Re Your ref 080080

Thank you for your letter of 31 January 2011 regarding the proposed residential subdivision Lot 112DP 1073791 Lyons Road, North Bonville (080080).

**CONCEPT ROAD DETAILS**

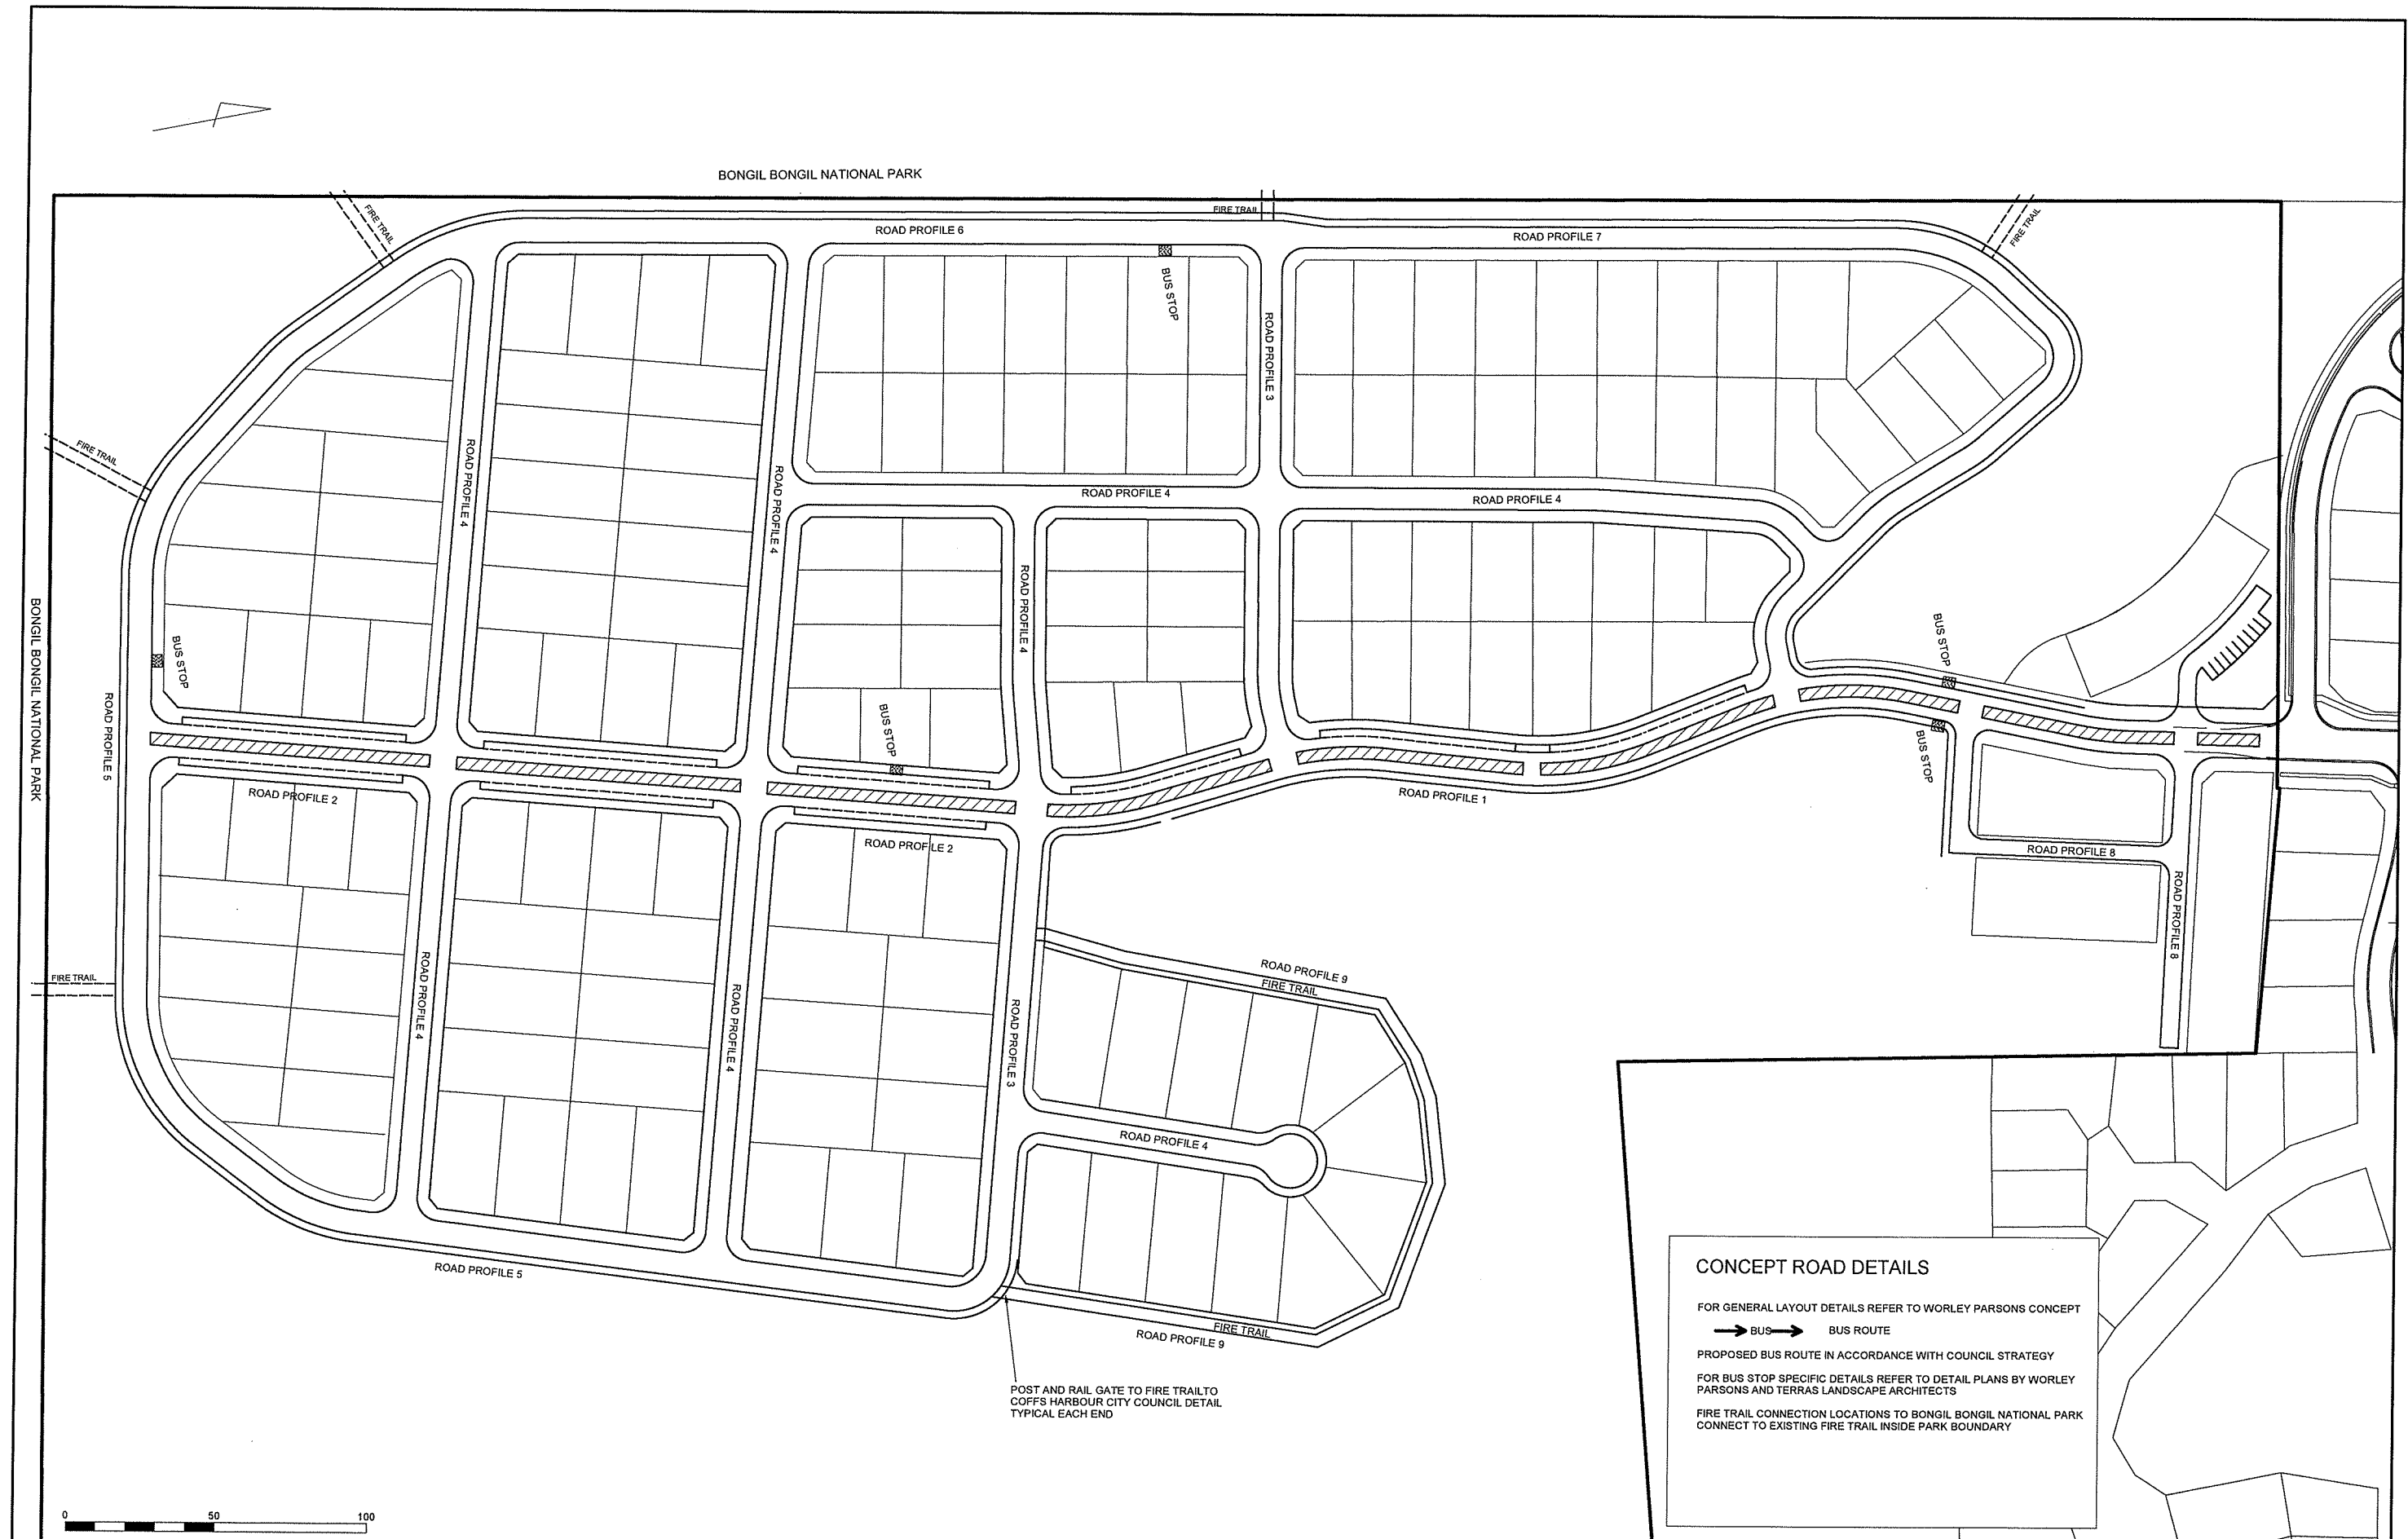
1. There is no detailed plan regarding traffic control.

The North Bonville DCP as issued by the Coffs Harbour City Council states that the traffic strategy is to "Establish a road hierarchy that restricts direct access to approved intersections only onto Lyons Road".

From the plans provided there would be only two access routes to the new subdivision – either from Bambara Road or Rutland Street.

We believe that having only these two access roads for a development of 196 allotments and 55 medium density senior independent units would create a huge increase in traffic flow in these 2 streets. We request that additional access points need to be provided to service a proposed development of this size.
